RECORD OF THE PRE-DEVELOPMENT APPLICATION MEETING

Date/Time of meeting: 25 March 2024, 10:00am

Property: 57-61 Archer Street & 34 Albert Ave, Chatswood

Description of Proposal: Construction of a shop-top/mixed use building.

PENTHOUSE
LEVEL 31

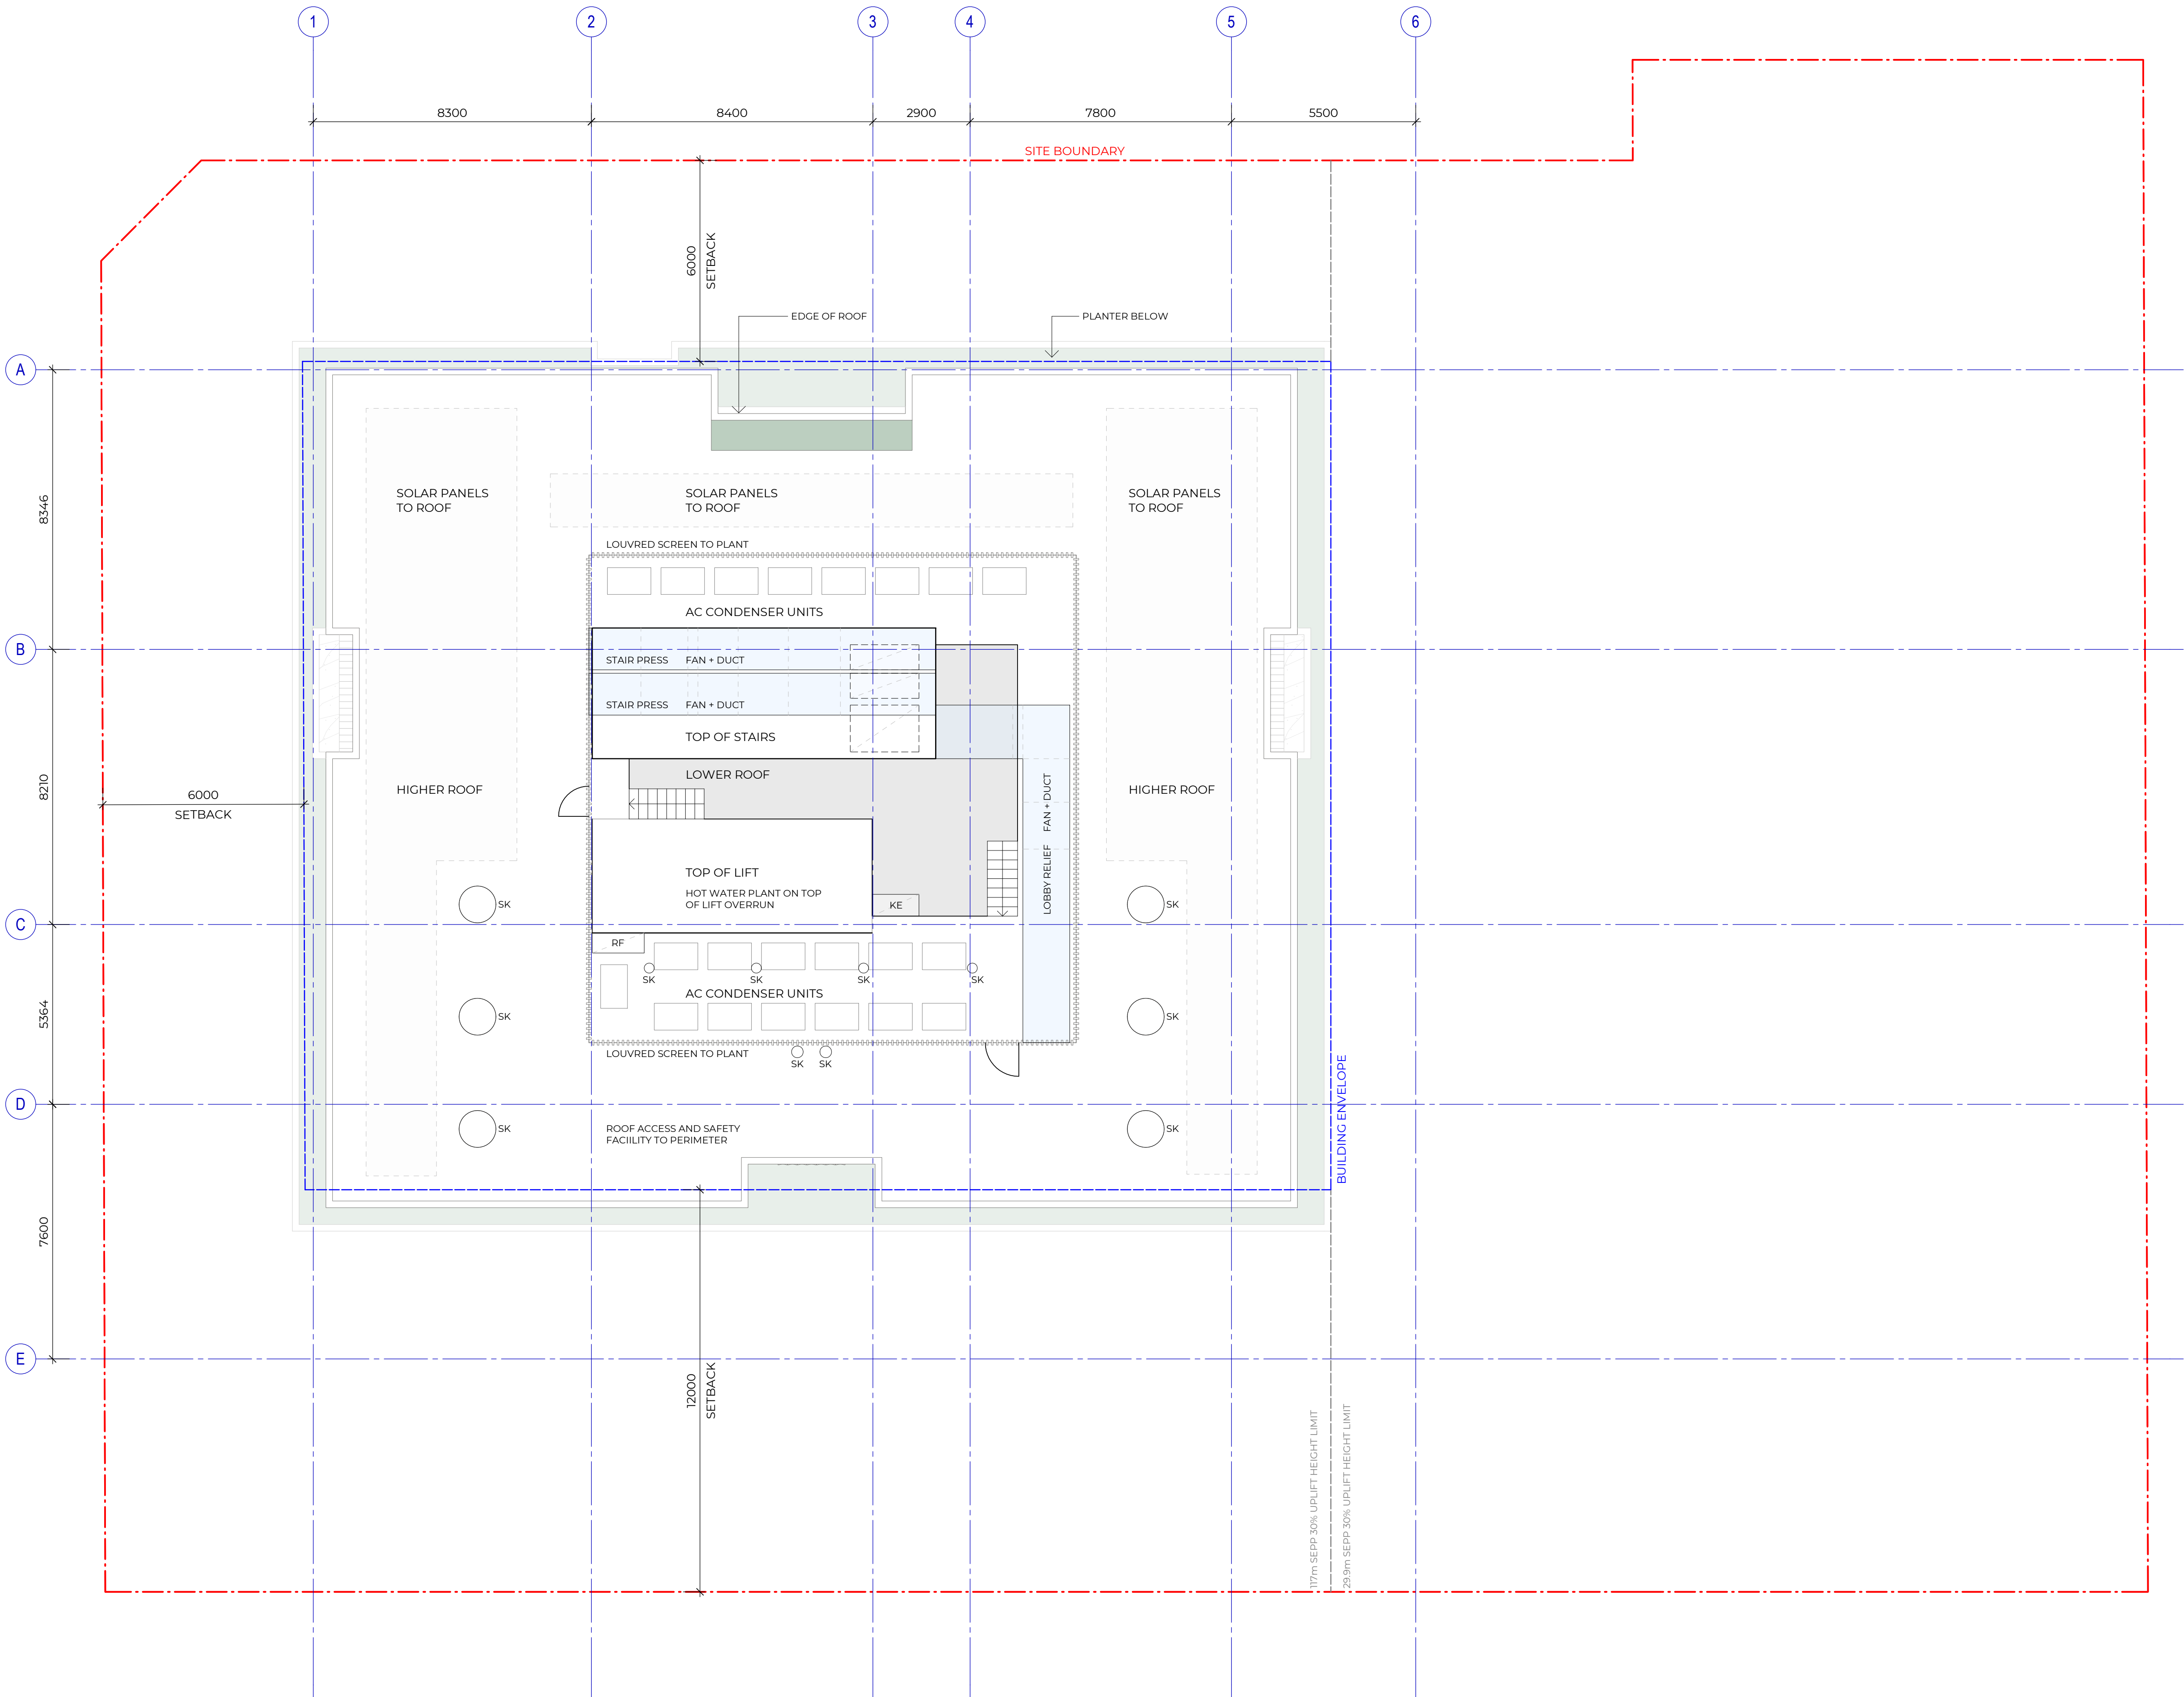
- The penthouse on top with communal space raises some use and amenity conflicts. Not an objection outright, but needs further thinking.
- Limited floor plans provided, however some units with minimal solar compliance seem to have lesser amenity. Understanding these are draft plans I leave this comment here.

- Base on the limit info. the parking seems to exceed Council's maximum. Parking rates are to comply.
- A question was raised about using the roof top communal spaces as an integrated space potentially with a health/gym use. Council have considered and believe that the use conflicts would create issues. Noting that families
